Our Ref: FP/15/12/

**The Town and Country Planning Act 1990 (as amended)
Town and Country Planning Development Management Procedure Order 2010 (as amended)**

**2 storey rear extension
119 Limmer Lane Felpham**

Existing Ground Floor Plan

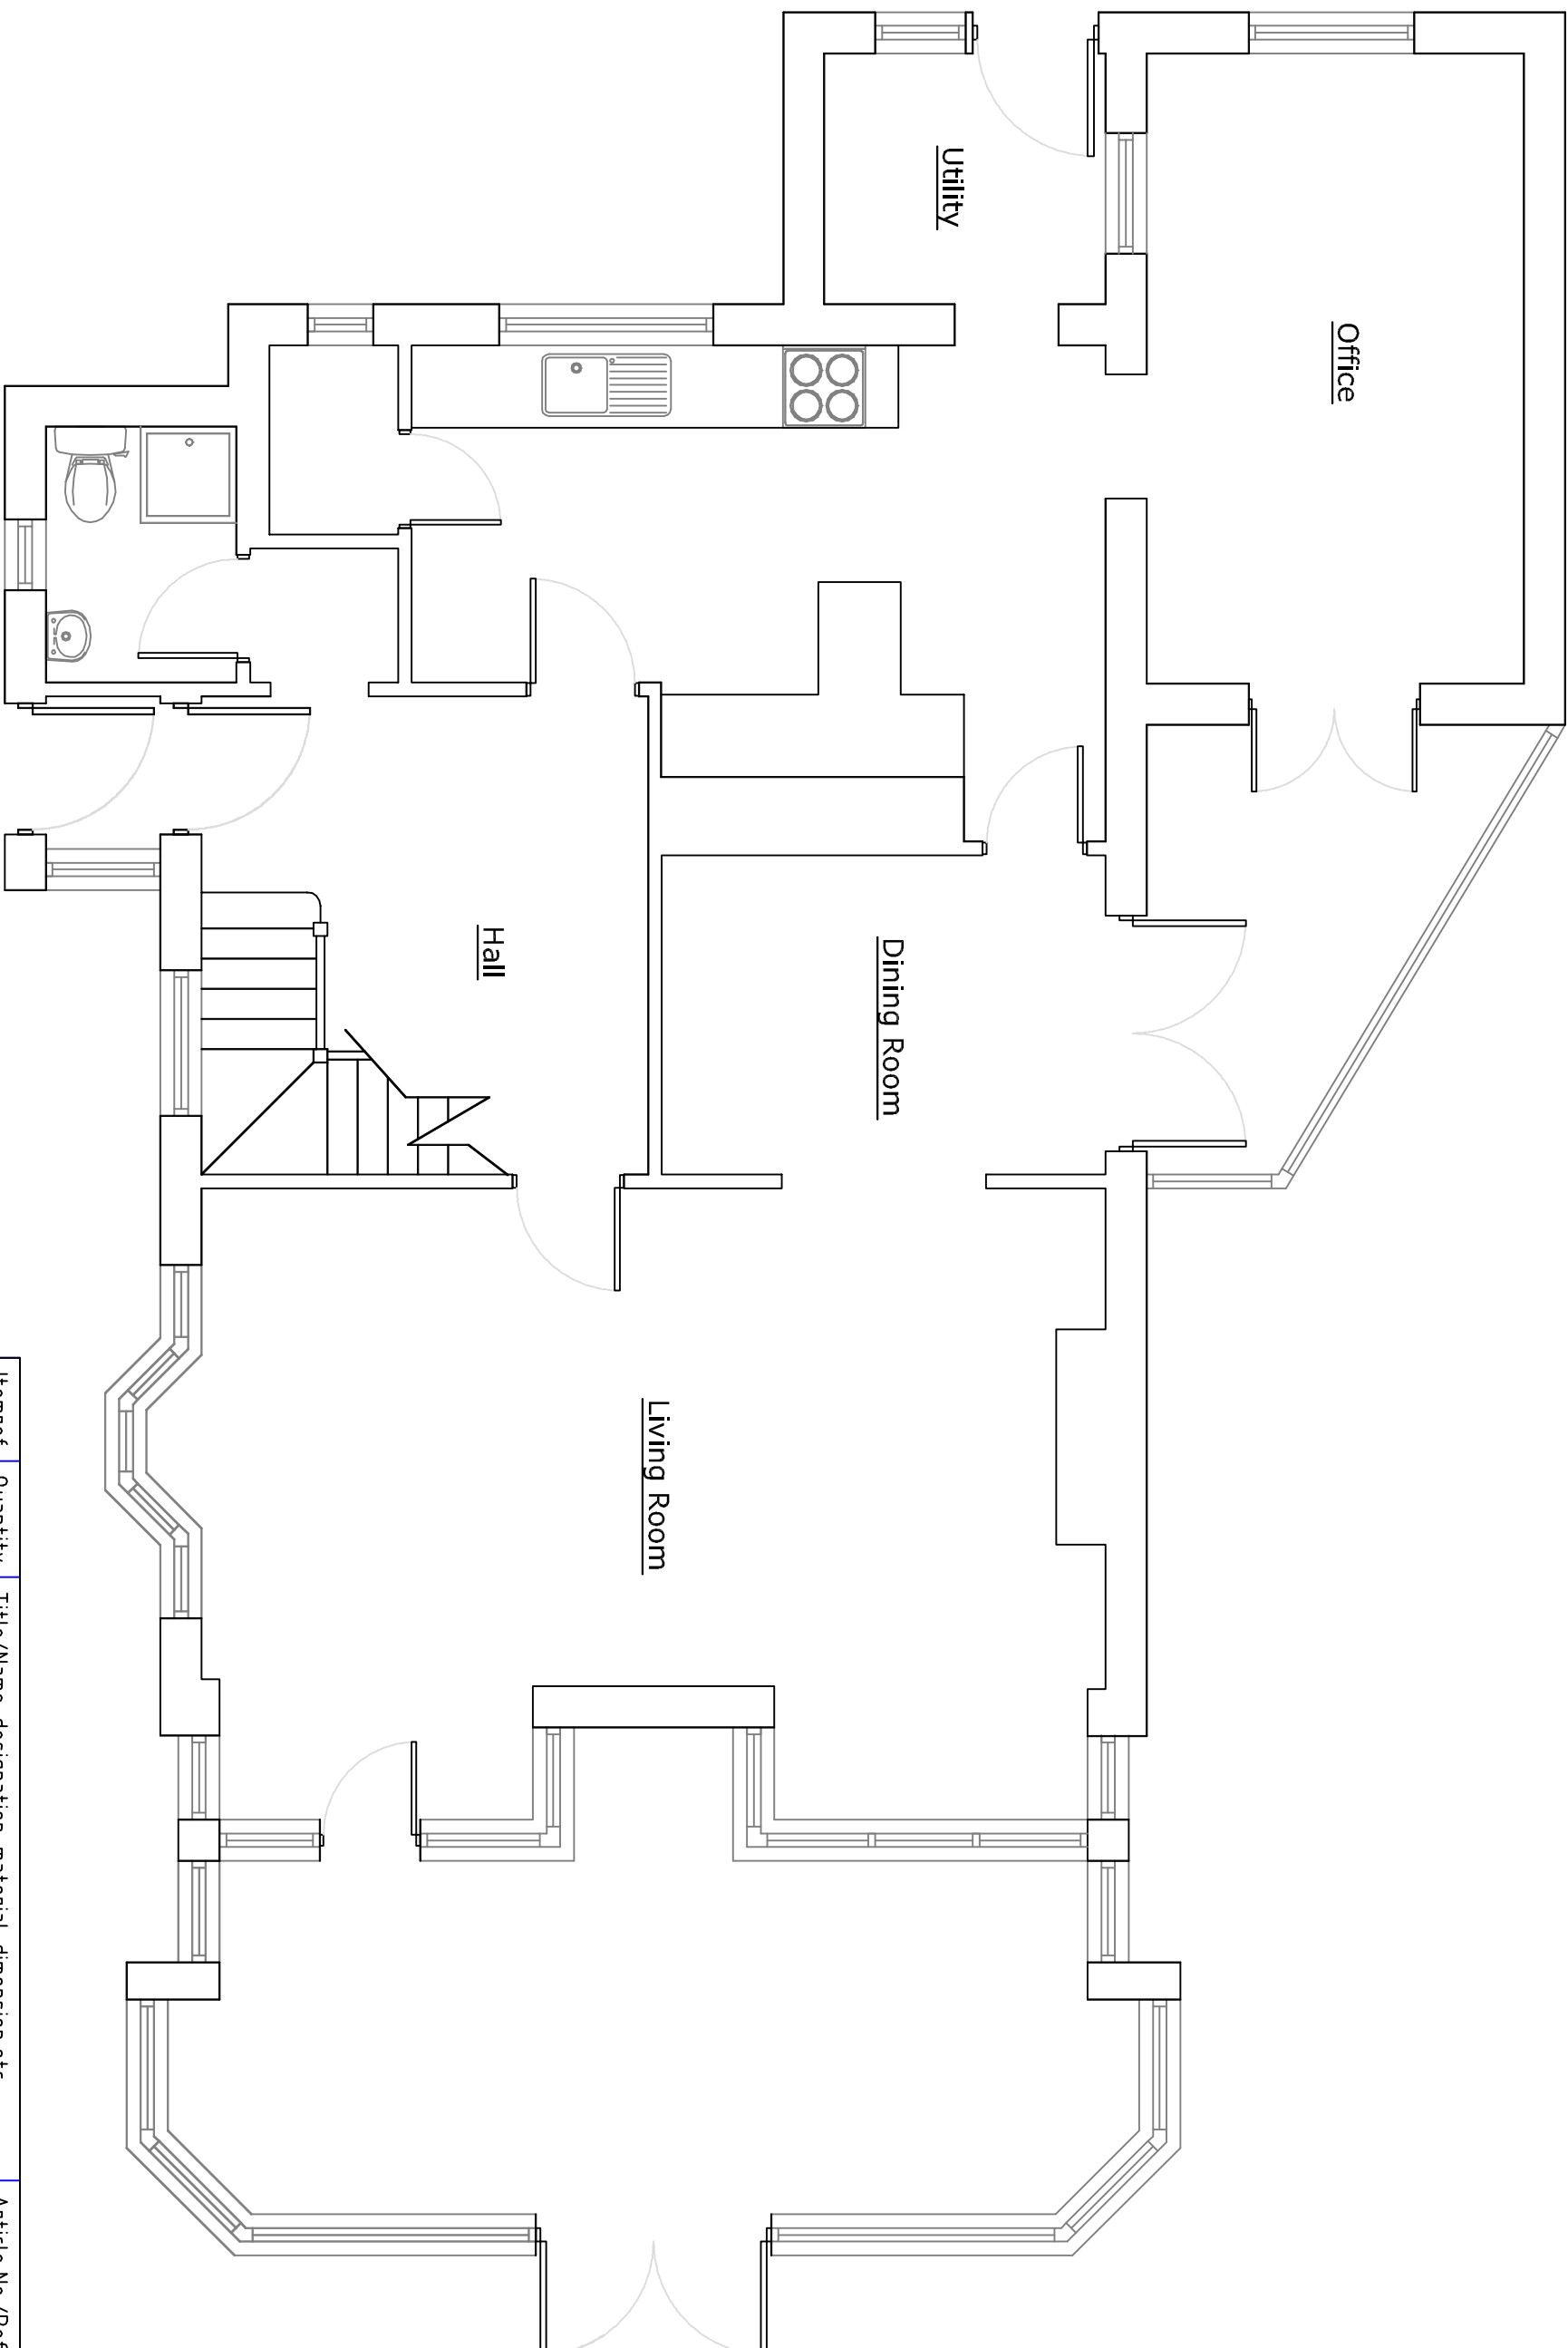
The existing and proposed ground floor plans do not accord with the existing and proposed side elevations. Please amend accordingly.

Proposed Rear Elevation

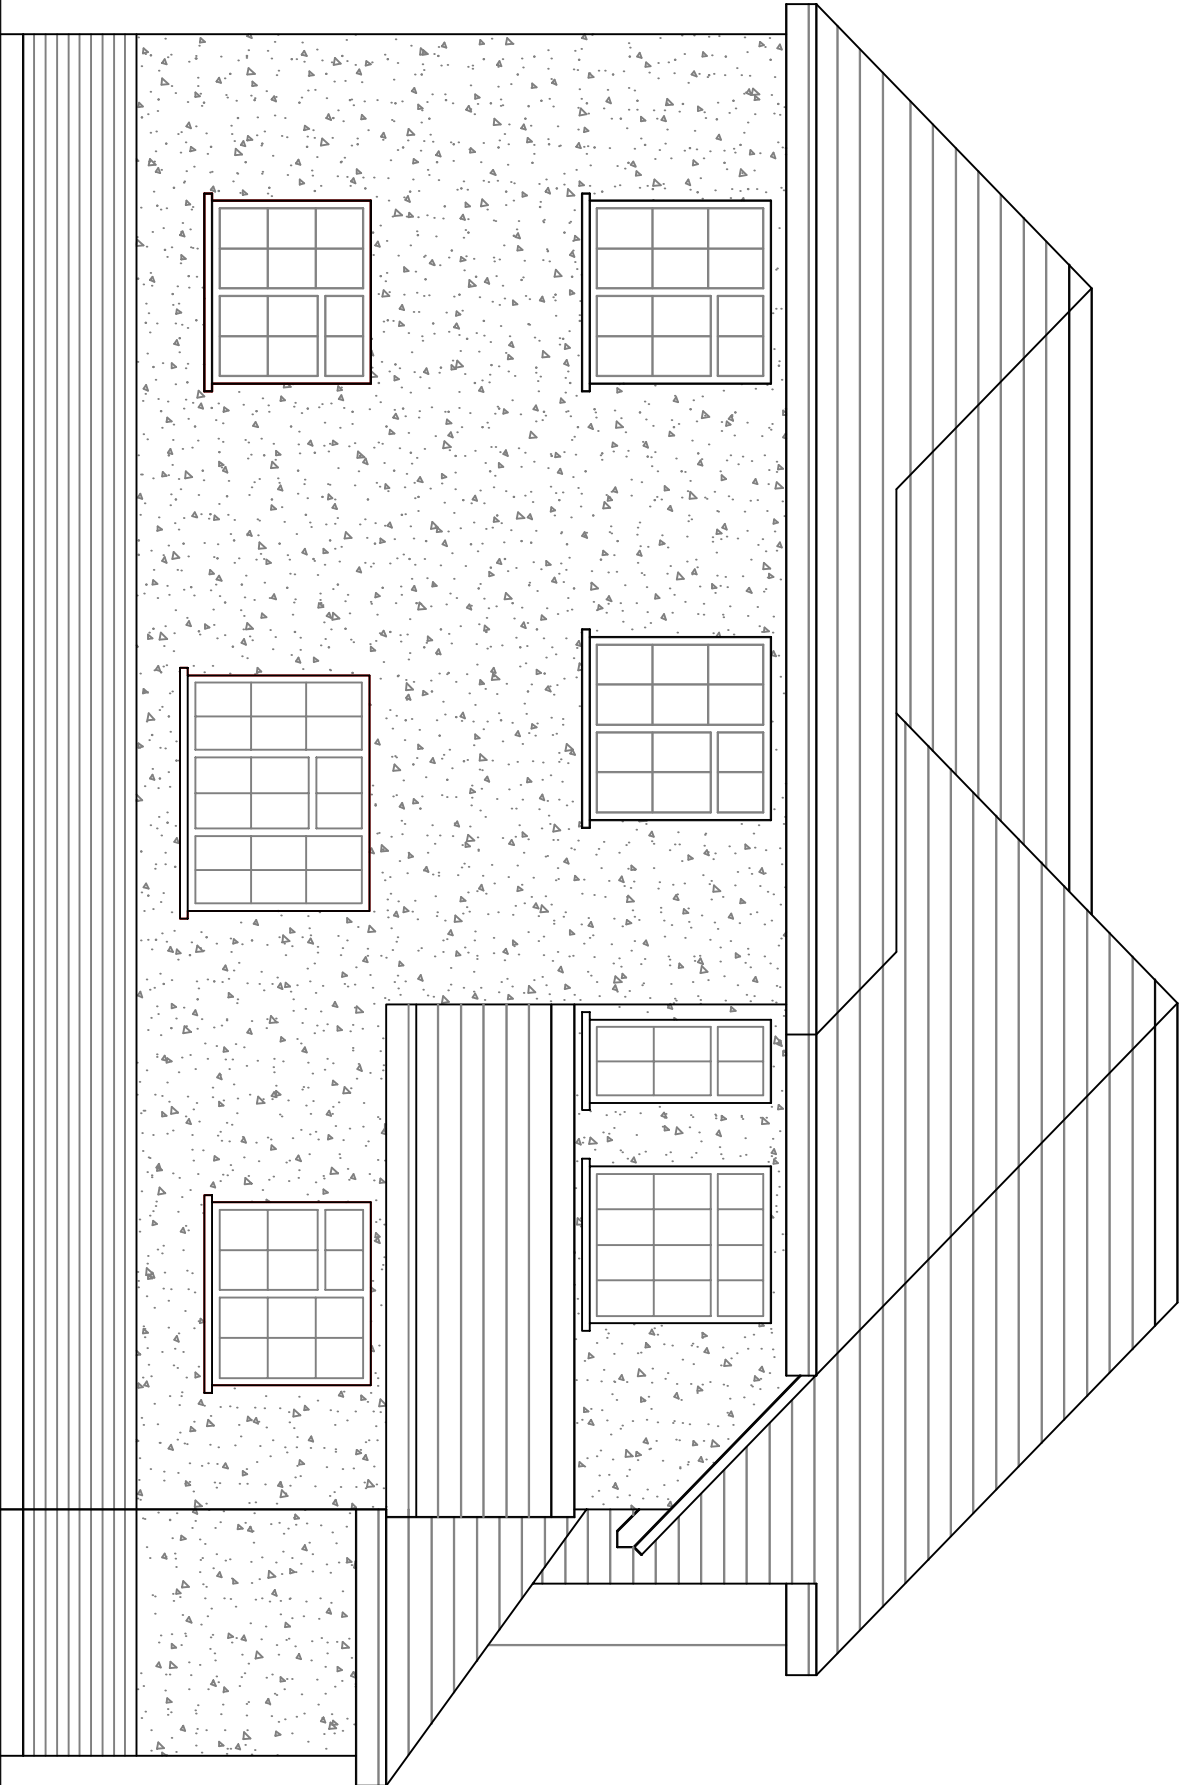
The proposed ground floor plans does not accord with the proposed rear elevation. Please amend accordingly.
